**Re:** Proposed Development of Residential Apartments and a Business Unit at 40 Station Approach, Ruislip, HA4 6RZ

As part of the fire consultancy works on the project, OAL have reviewed the potential proposal to use the electric-opening sliding roof vent to provide occupant access to the roof terrace.

Drawing: Proposed East Elevation (Section 73 application) Size: A3

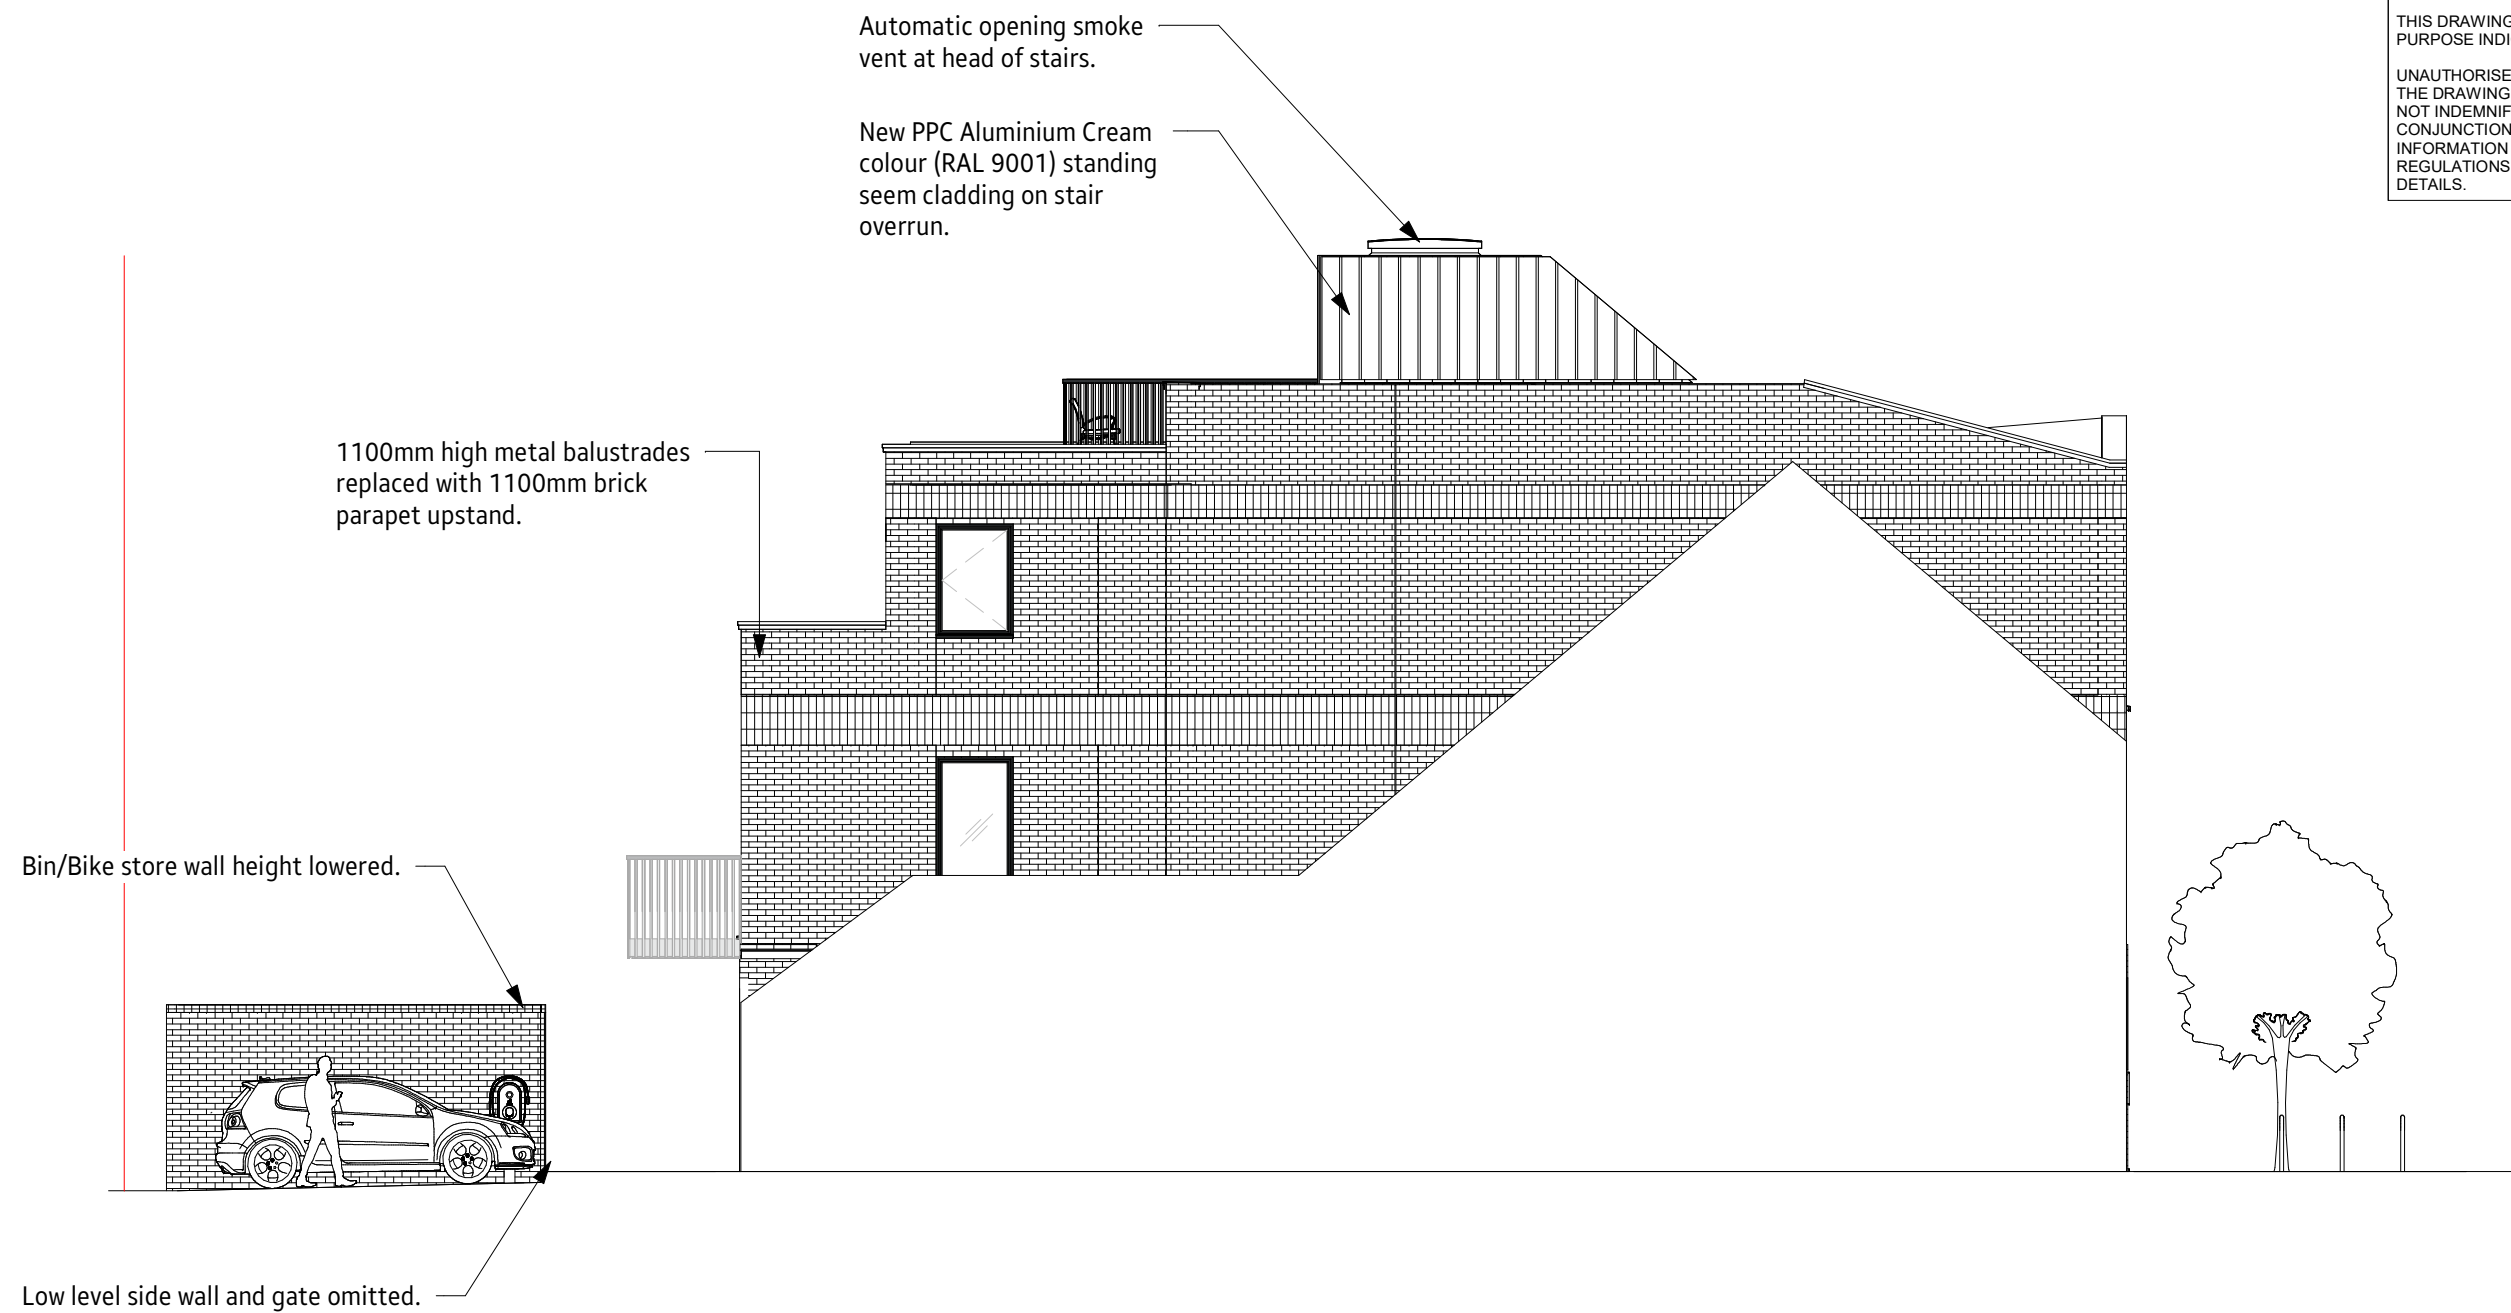
The Station Approach is a single stair building and the roof terrace will be an occupied space accessible to the residential unit occupants. Therefore, there will be a heavy reliance on the glazing system to operate effectively to ensure the means of escape is not inhibited at any time.

As far as OAL is aware, there is no testing that has been done to support the use of the proposed vent for means of escape purposes. Therefore, given the limited information received to date, it is unlikely the system will achieve the necessary requirements to support the provision of means of escape via the vent.

It is therefore advised that the access to the roof terrace is provided via conventional means, such as extending the staircase to serve the roof terrace level.

As it is not possible to confirm the suitability of the proposed roof vent for means of escape purposes, it is recommended that the stair is extended to serve the roof terrace level.
